Appendix F. Road safety audit response report template for stages 1, 2 and 3 only

Report title:	PROPOSED COMMERCIAL DEVELOPMENT, HOUGHTON MAIN, BARNLEY – PROPOSED GHOST ISLAND PRIORITY JUNCTION Combined Stage 1 and 2 Road Safety Audit
Date:	21st March 2022
Document reference and revision:	RSI-MH-0322-004 Issue 1.1
Prepared by:	Road Safety Initiatives
On behalf of:	Barnley Metropolitan Borough Council

Project:	Houghton Main, Barnley
Report title:	Stage ½ RSA Designers response
Prepared by:	
Name:	Rik Binnersley
Position:	Principal Engineer
Signed:	
Organisation:	RWO Group Leeds
Date:	30.03.2022
Approved by:	
Name:	Andrew Fairburn
Position:	Director
Signed:	
Organisation:	RWO Group Leeds
Date:	30.03.2022

DESIGN NOTES:

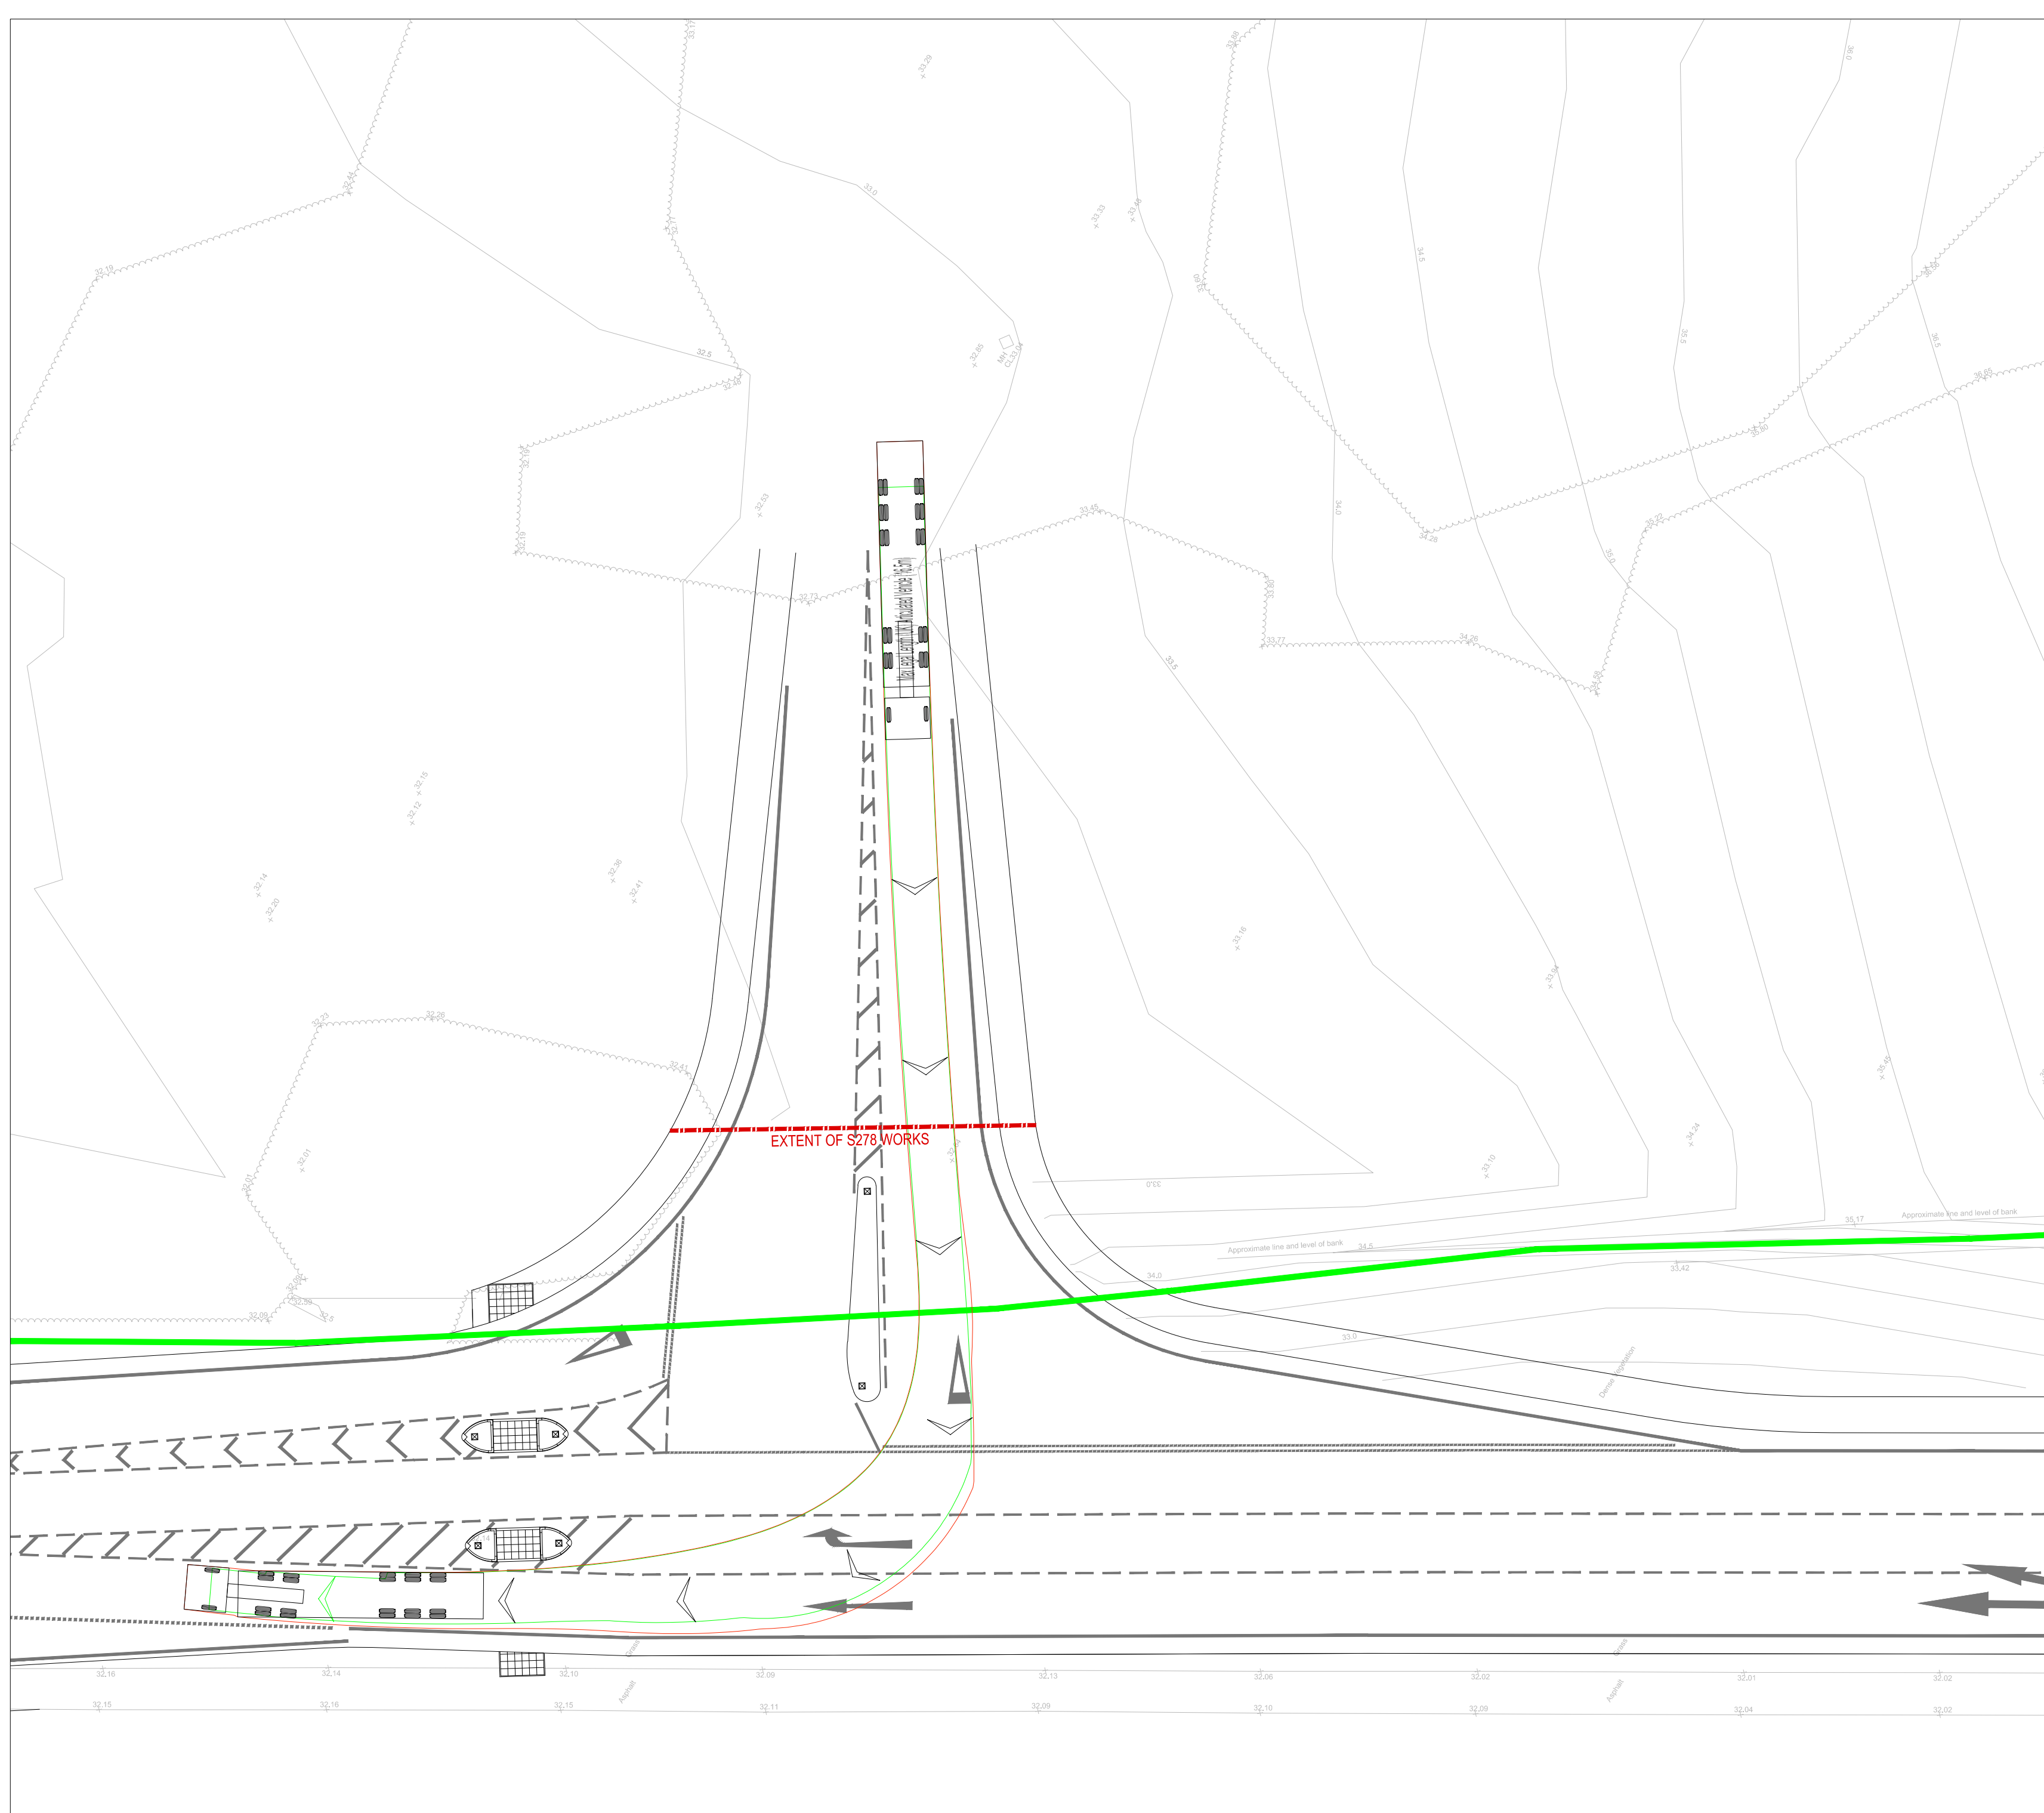
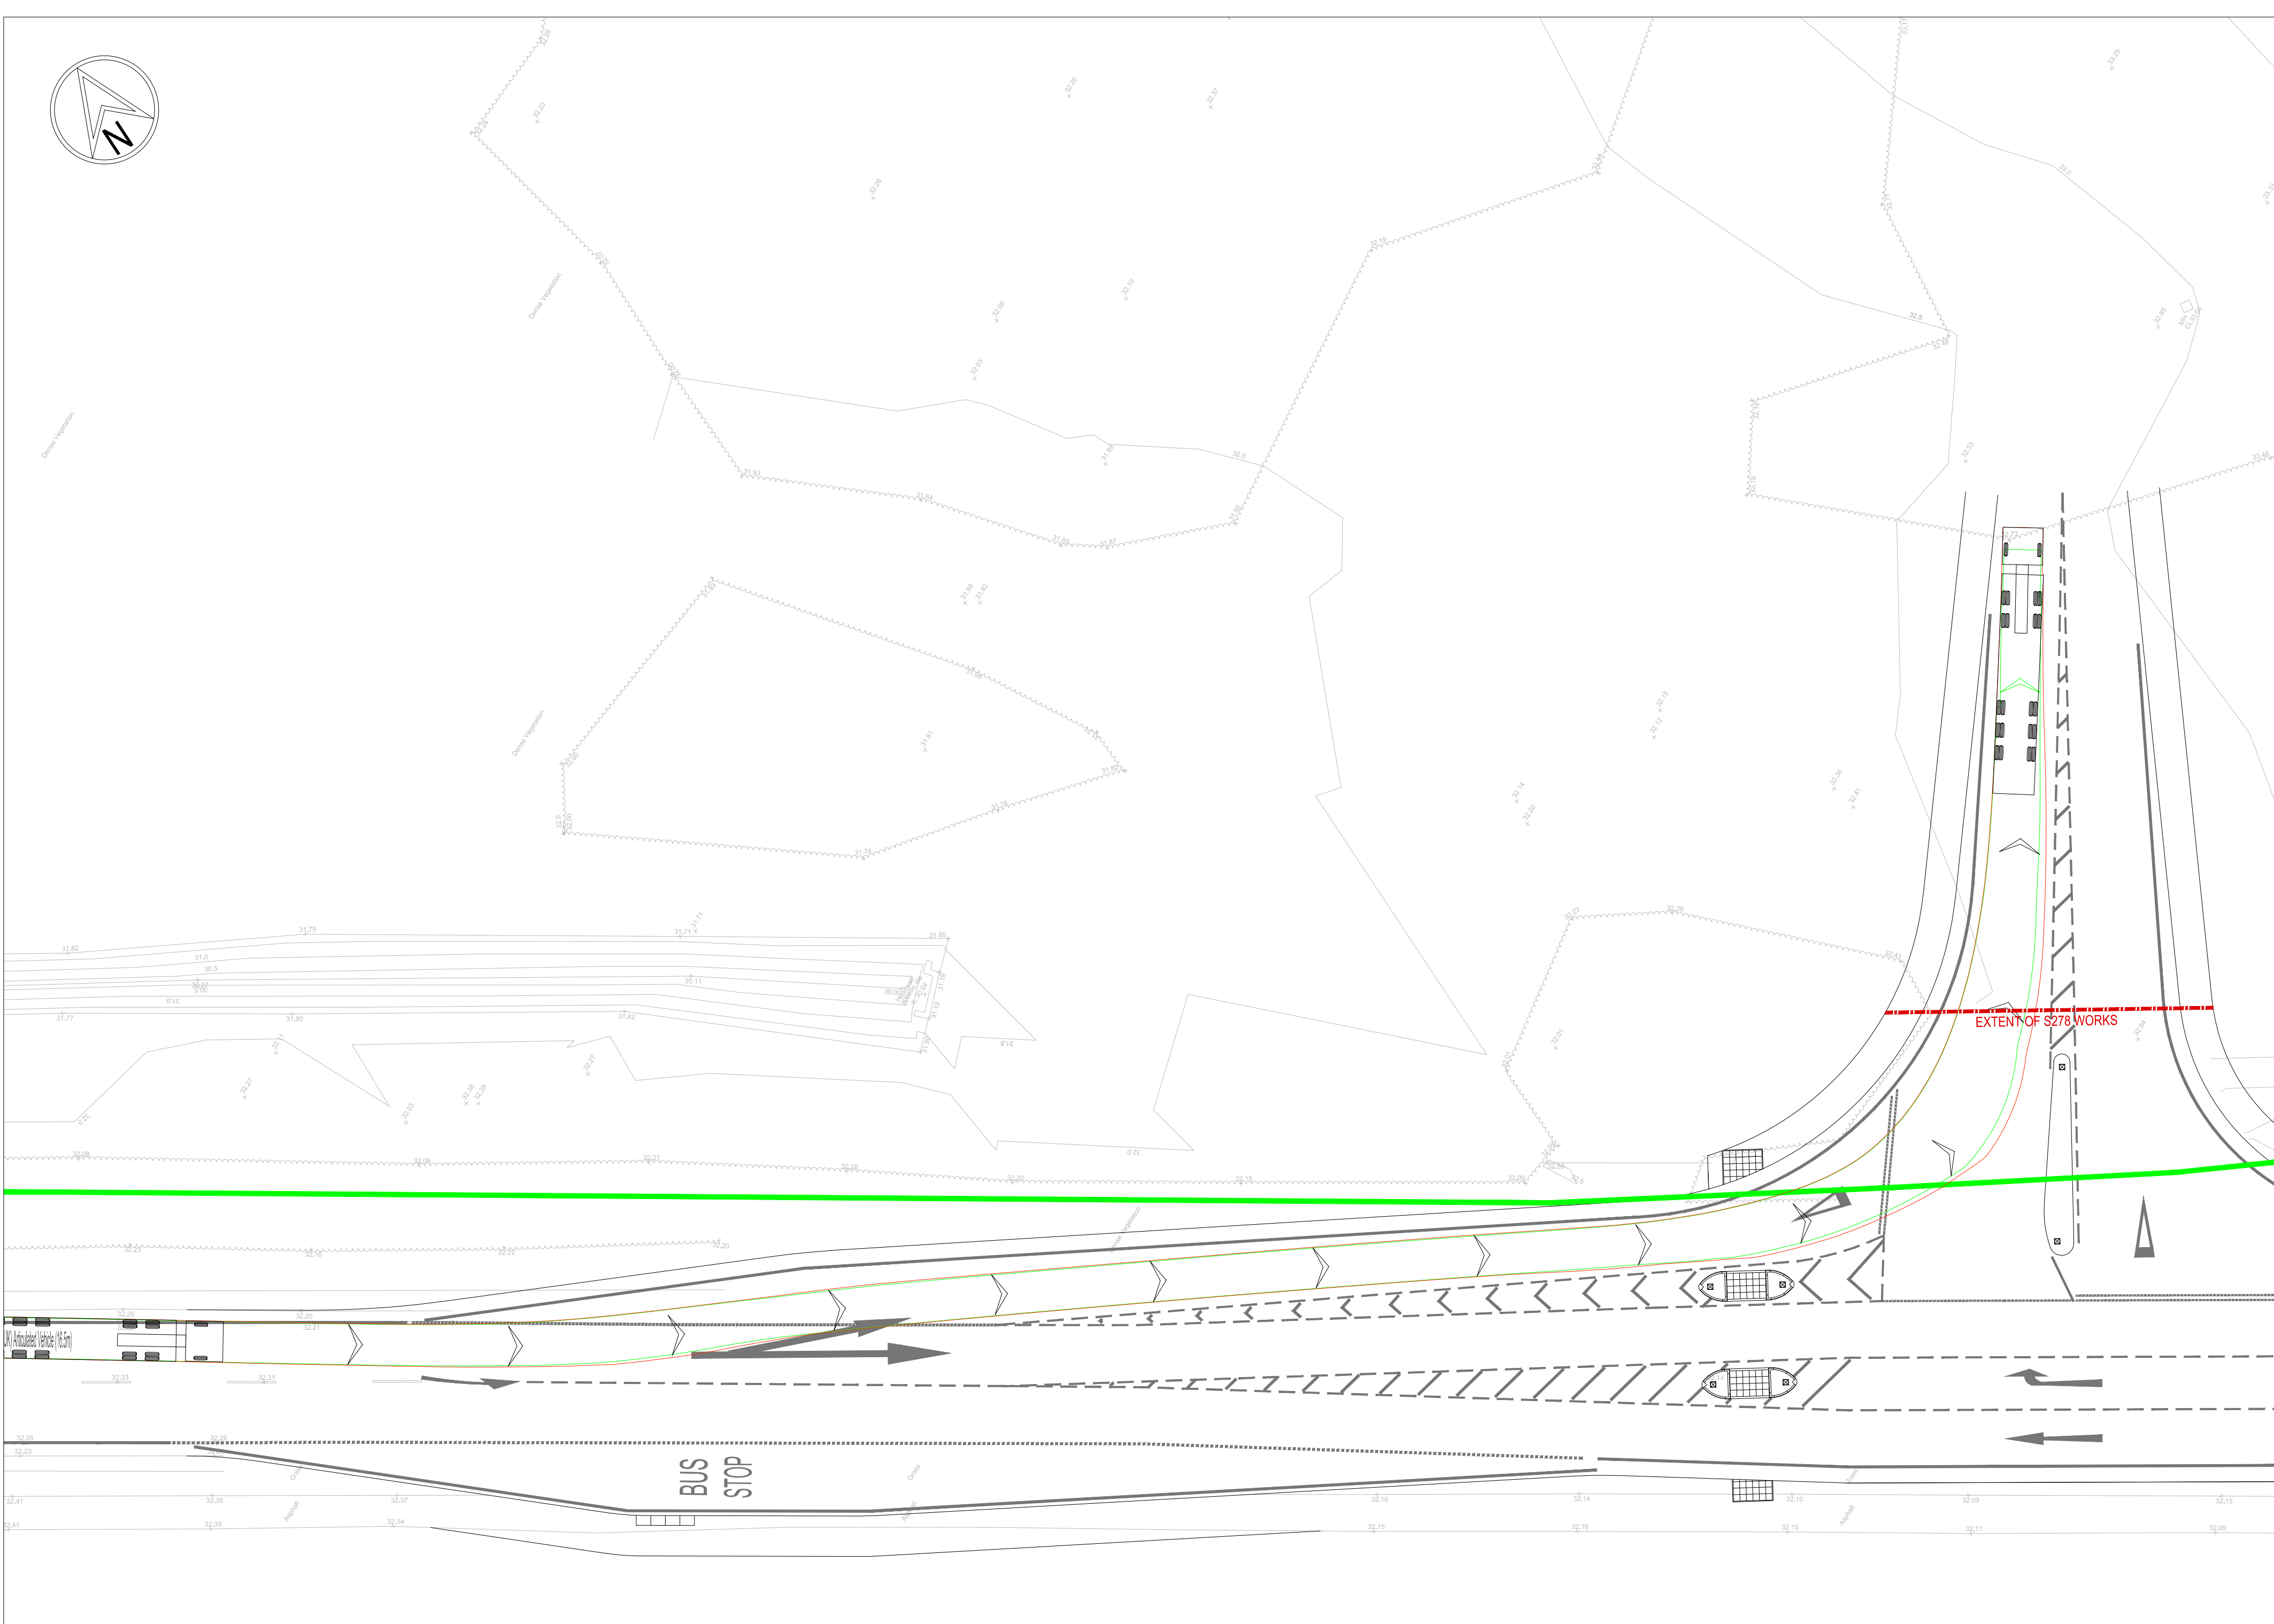
RSA problem	RSA recommendation	Design organisation response	Overseeing Organisation response	Agreed RSA action
3.1.1 - Inadequate drainage may lead to loss of control collisions. It would appear that no drainage is to be provided adjacent to the new kerblane (currently consists of informal 'over the edge' type drainage). The current system results in standing water, which was evident during the site visit. The carriageway is proposed to be widened, which will increase the amount of surface water to be removed and there will be nowhere for it to disperse, which could exacerbate the situation.	It is recommended that adequate drainage is provided.	Agree – At the time of submission of the drawings a drainage scheme for the works was not available. Since this time a preliminary drainage scheme has been produced (Y21011-D1008 – Section 278 Highway Drainage Layout) highlighting how the scheme will be drained.

3.3.4 – Inadequate drainage may lead to pedestrian conflicts. It would appear that no drainage is to be provided adjacent to the new kerbline (currently consists of informal 'over the edge' type drainage). The current system results in	It is recommended that adequate drainage is provided.	Agree – At the time of submission of the drawings a drainage scheme for the works was not available. Since this time a preliminary drainage scheme has been produced (Y21011-D1008 – Section 278 Highway Drainage Layout) highlighting how the scheme will be drained. However, it should be noted that the existing ponding issues seem to be caused by vegetation
